I want to submit my comments regarding planning applications 2021/1089 & 2021/1090, which will be spread under several headers and covering a variety of areas – some of which are still present from my first submission in 2021.

Residential Plan – The first Plot

SITE LAYOUT NTS

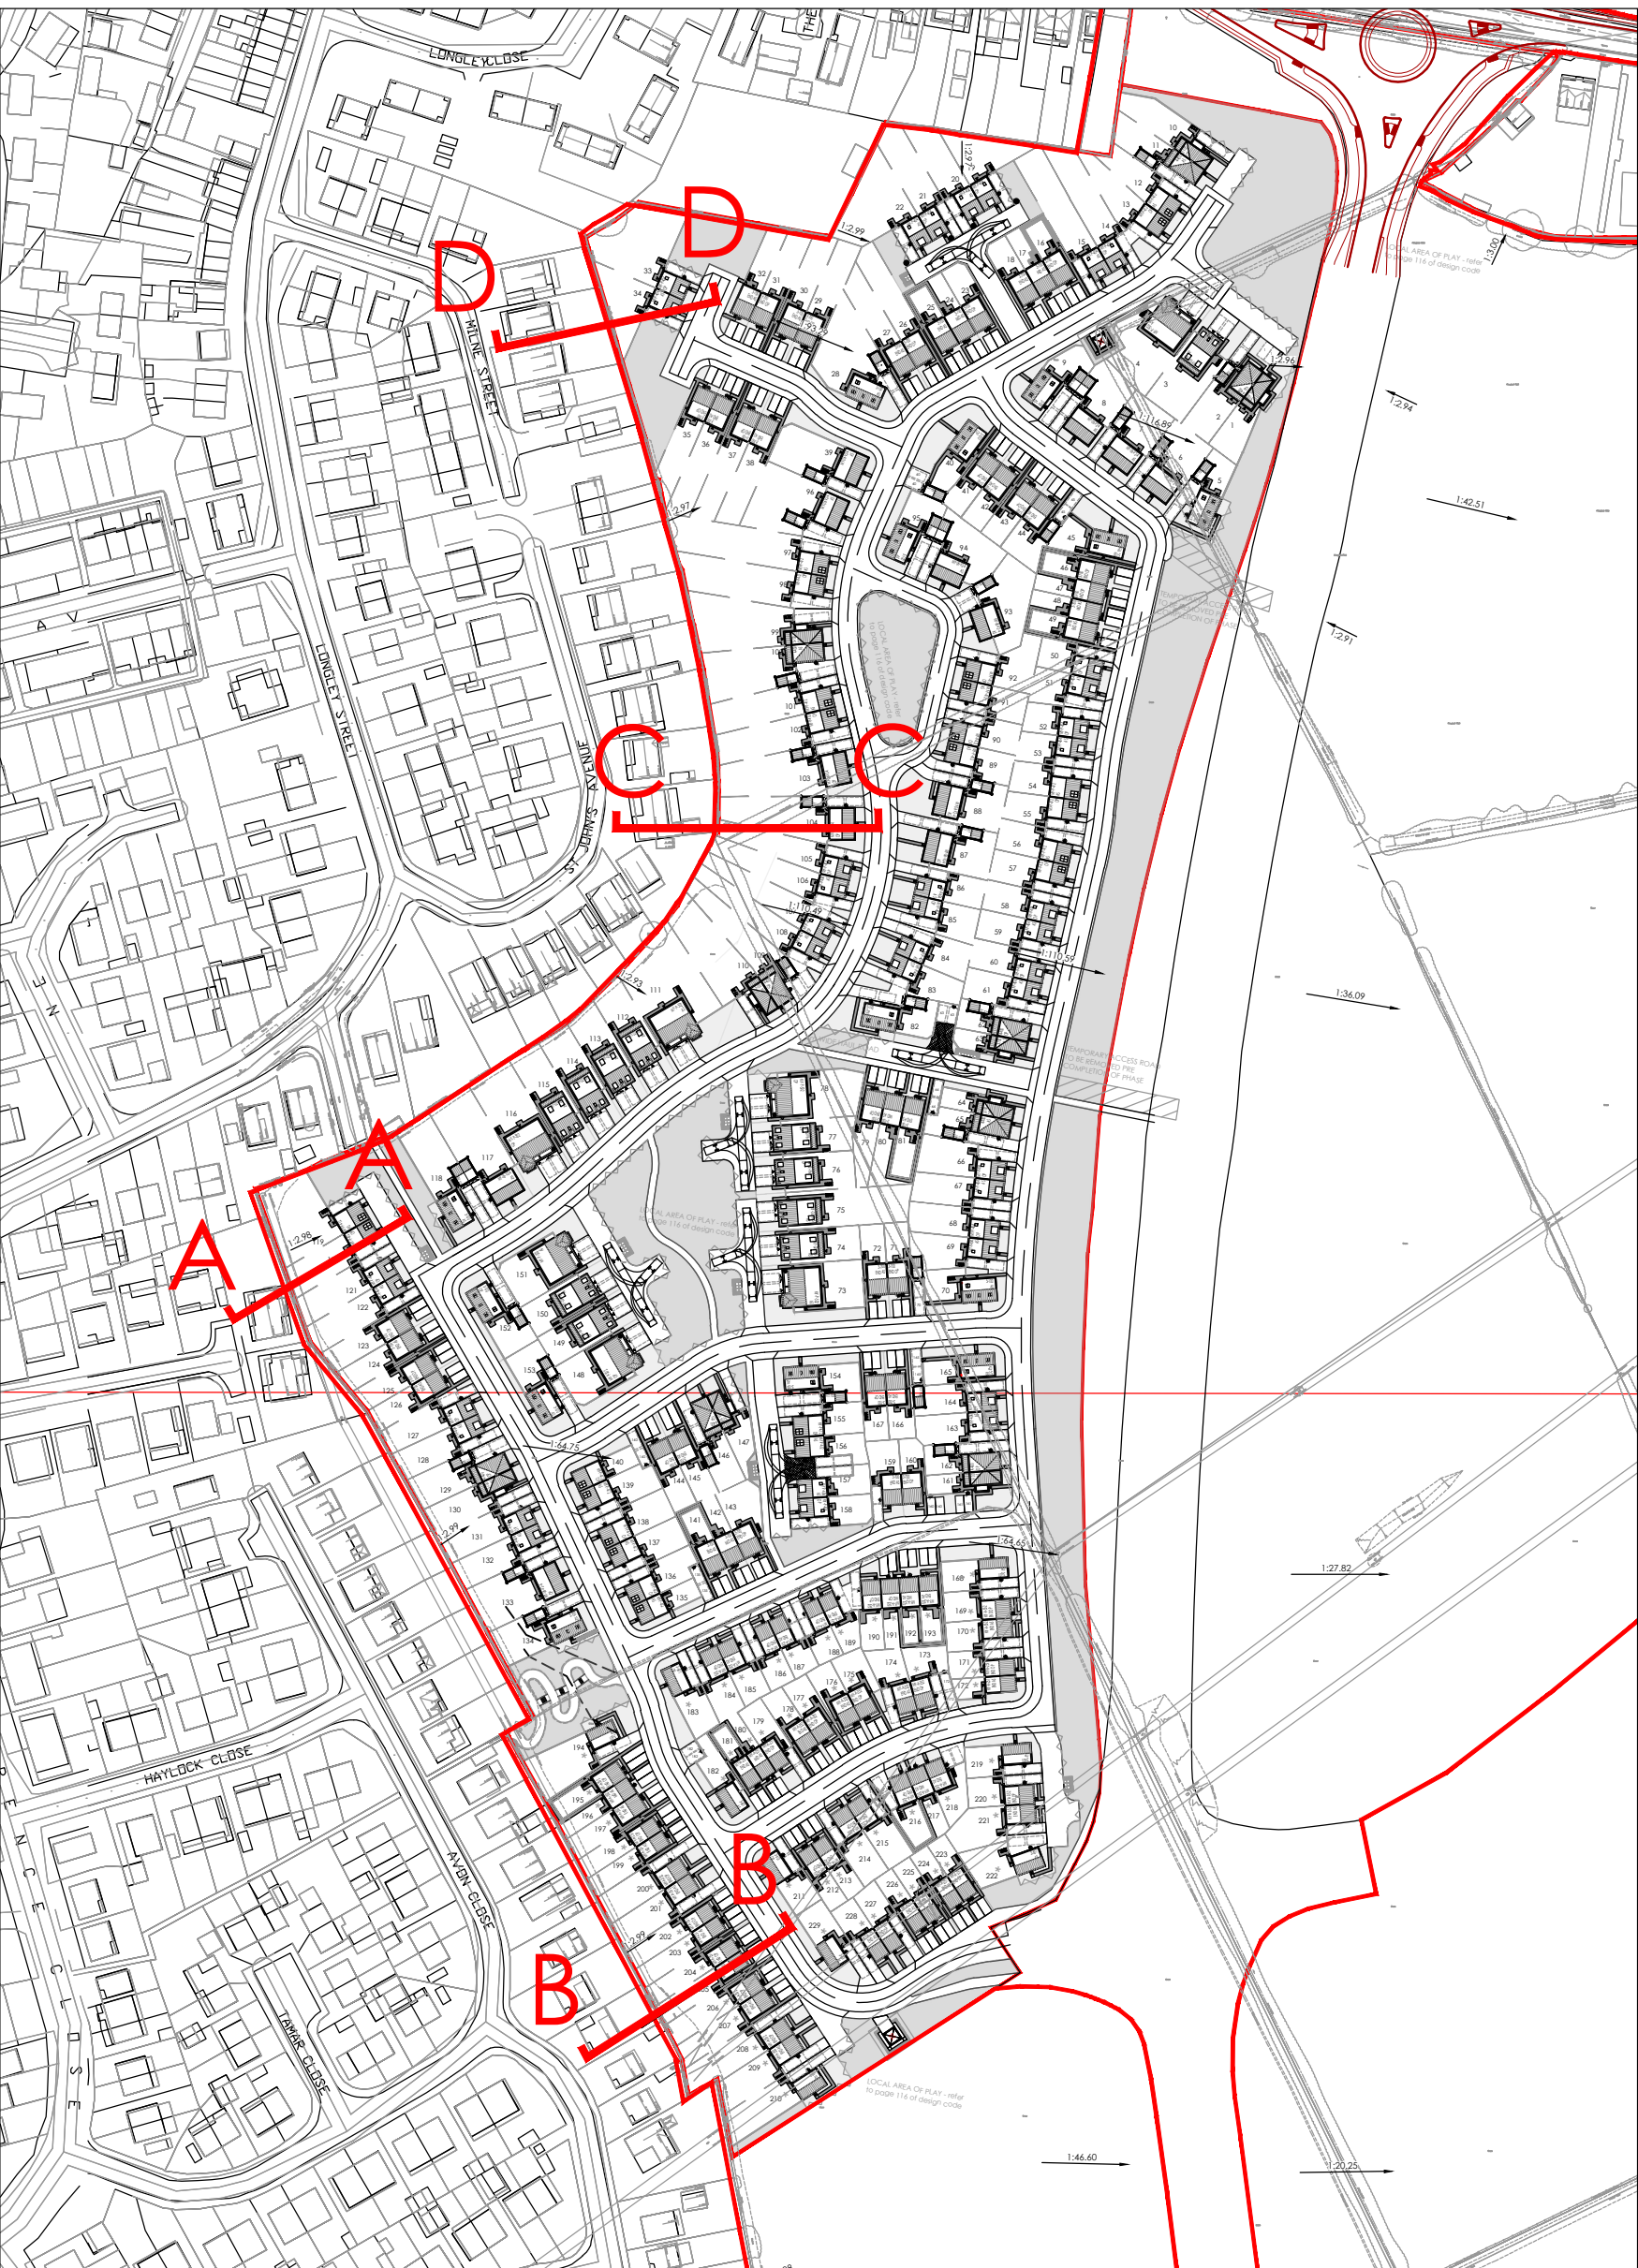
I will repeat a concern and repeat my annoyance of assurances broken. Councillors and BMBC were assured that no three-story houses would be backing up to the bungalows on the western side. As specifically seen in the Phase One residential development plan, this is still false.

Semantics could be used that these are “2.5 stories”, but the harsh reality is that this is a third story, and houses, as seen in the residential plot, meet this. Specifically, these are houses 117, 118, 119, 185, 189, 190, 196, 197 and 200. My residents want their privacy respected, and this plan blatantly opposes that.

Furthermore, residents of the Darton West ward on St. Johns Avenue will also see their privacy breached with house 32. This could be the case with houses 95 to 108, though the garden lengths seem adequate to supply the distance.

While not perfect, I have already indicated that this could have been prevented by a buffer zone of trees between the houses. That this – and previous assurances – have been ignored, and the privacy of residents in bungalows is being blatantly ignored, is deeply concerning.
